MMC Employee Garage site plan review - revised plans and Planning Board timeline

Tue, Aug 28, 2018 at 3:59 PM

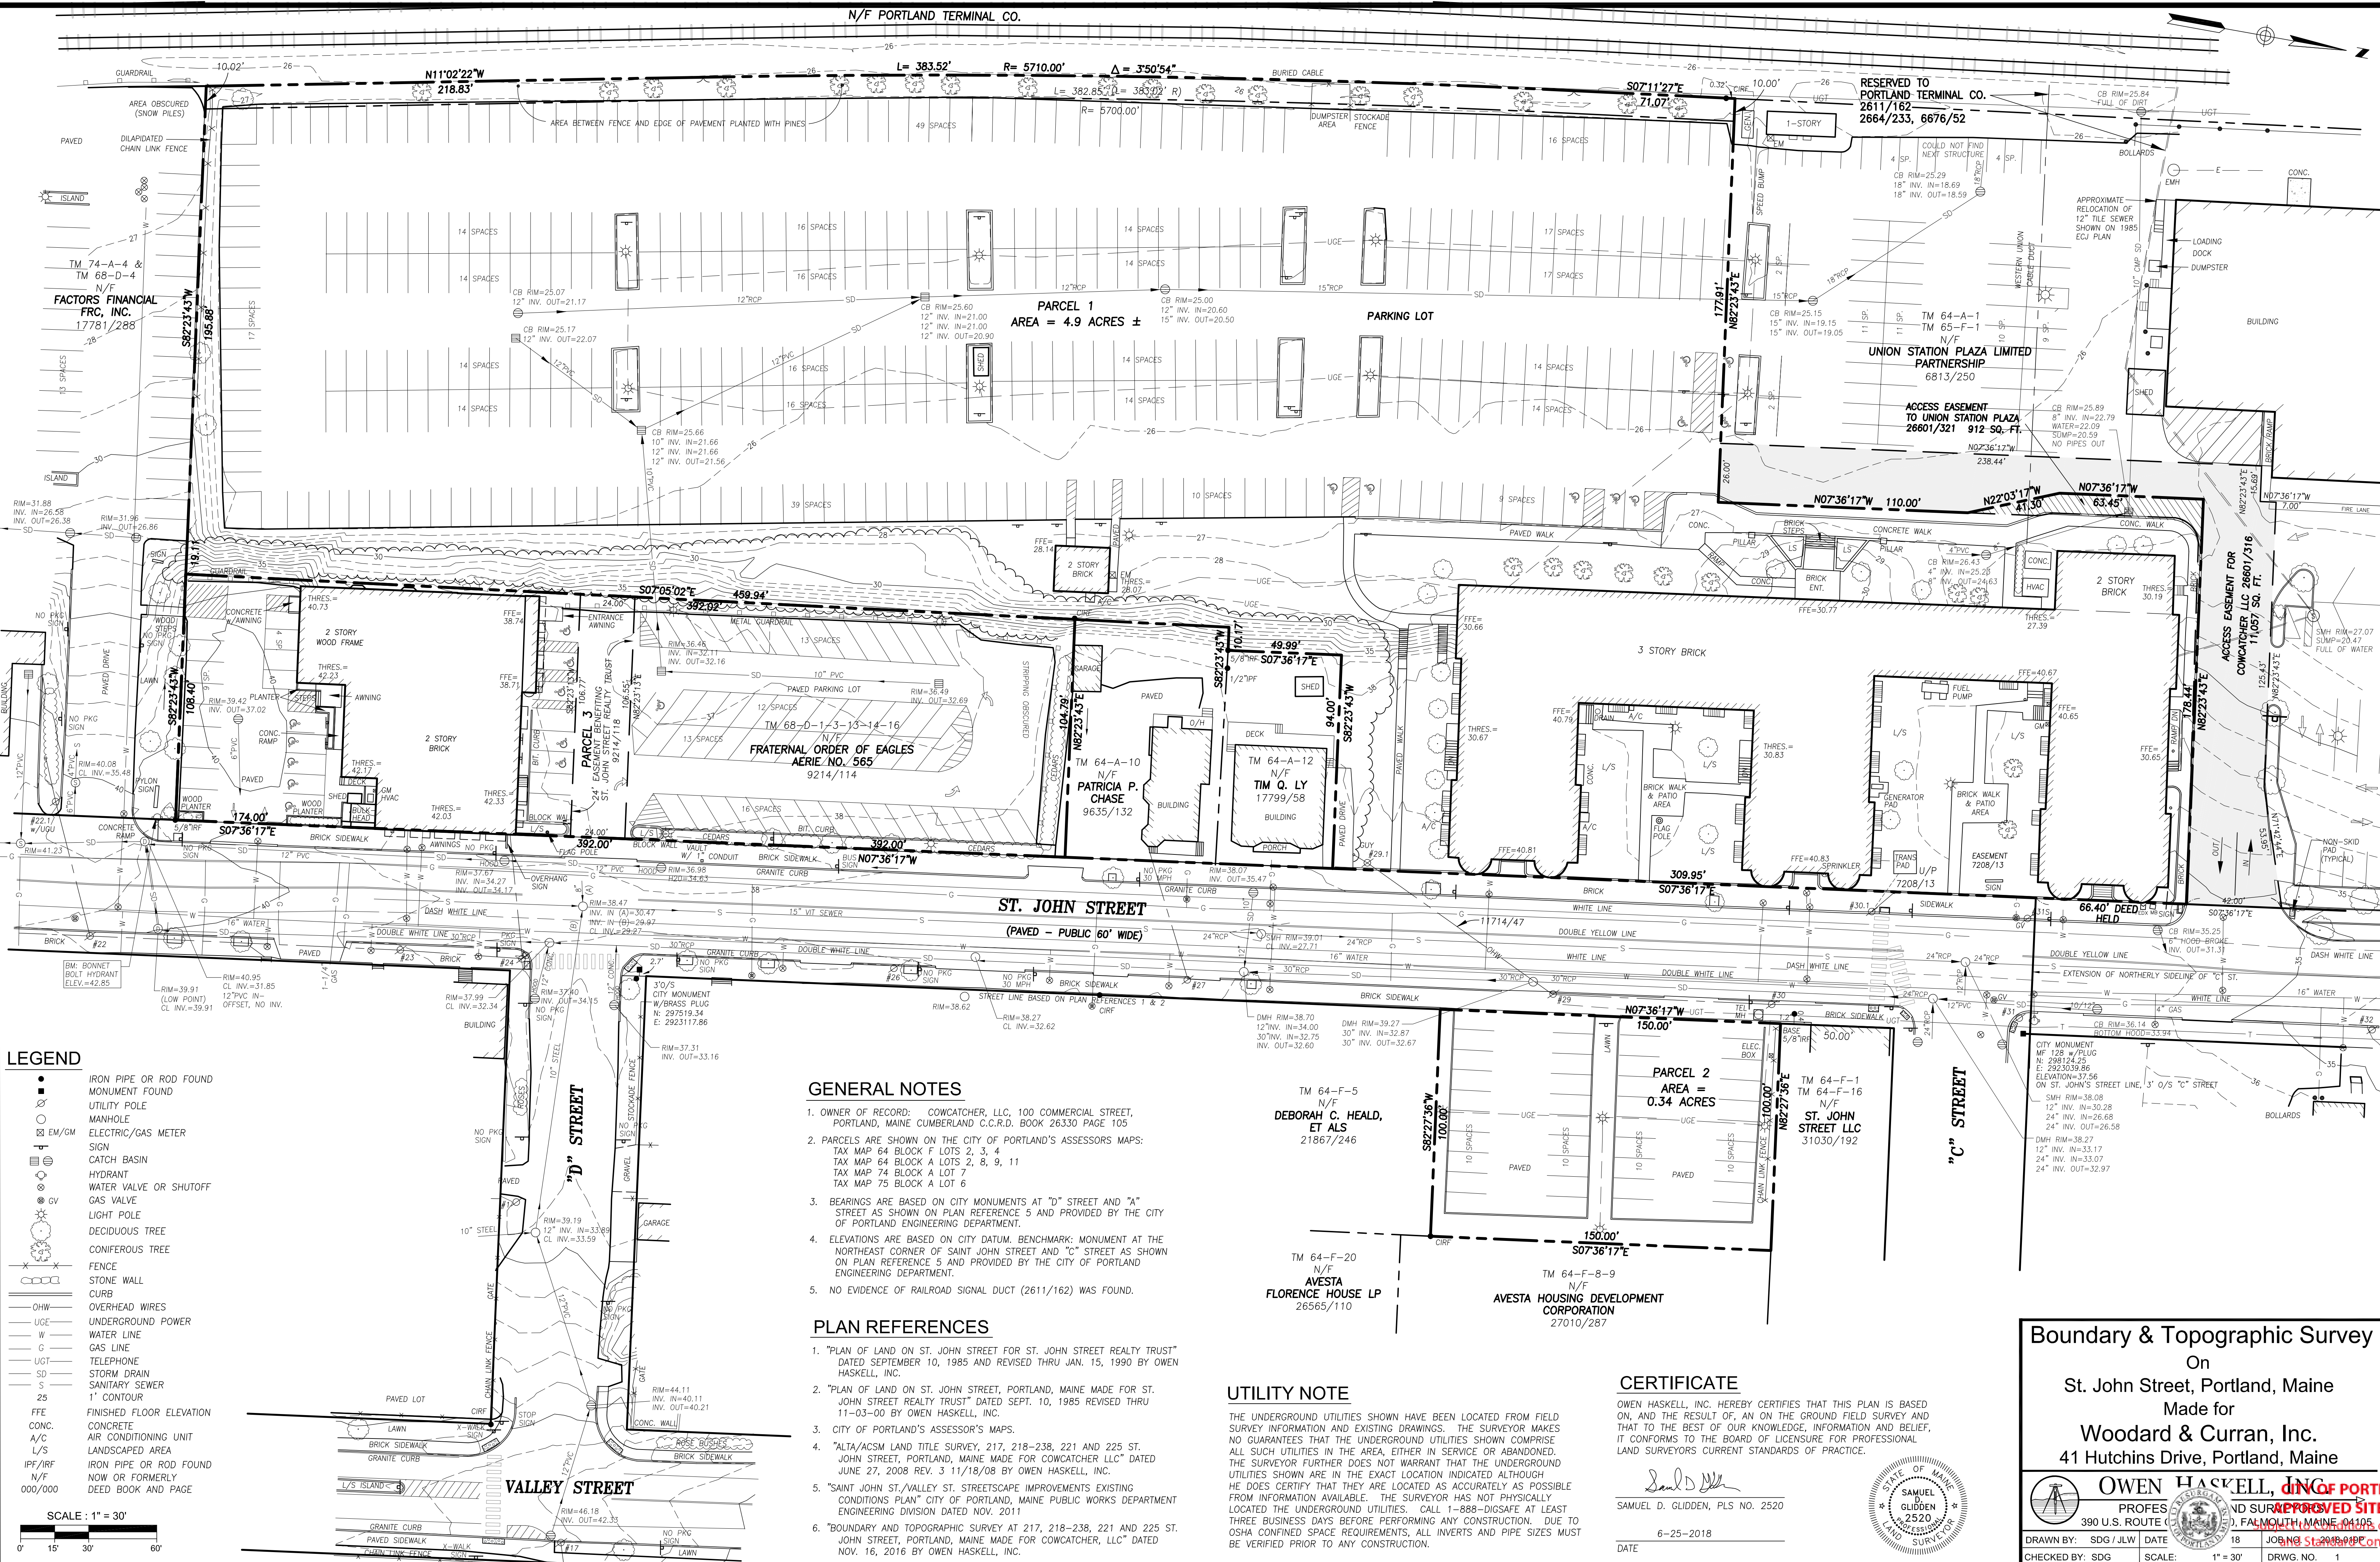
Looking at C-100, the site plan, is on-street parking still going to be allowed beginning basically across the street from our house where the intersection transition ends?

MMC says that constructing curbs and sidewalks, and better defining D Street, is going to allow more on-street parking there, but I don't see where there is any room for parking at all. The driving lanes seem to take up the entire width of the street between sidewalks.
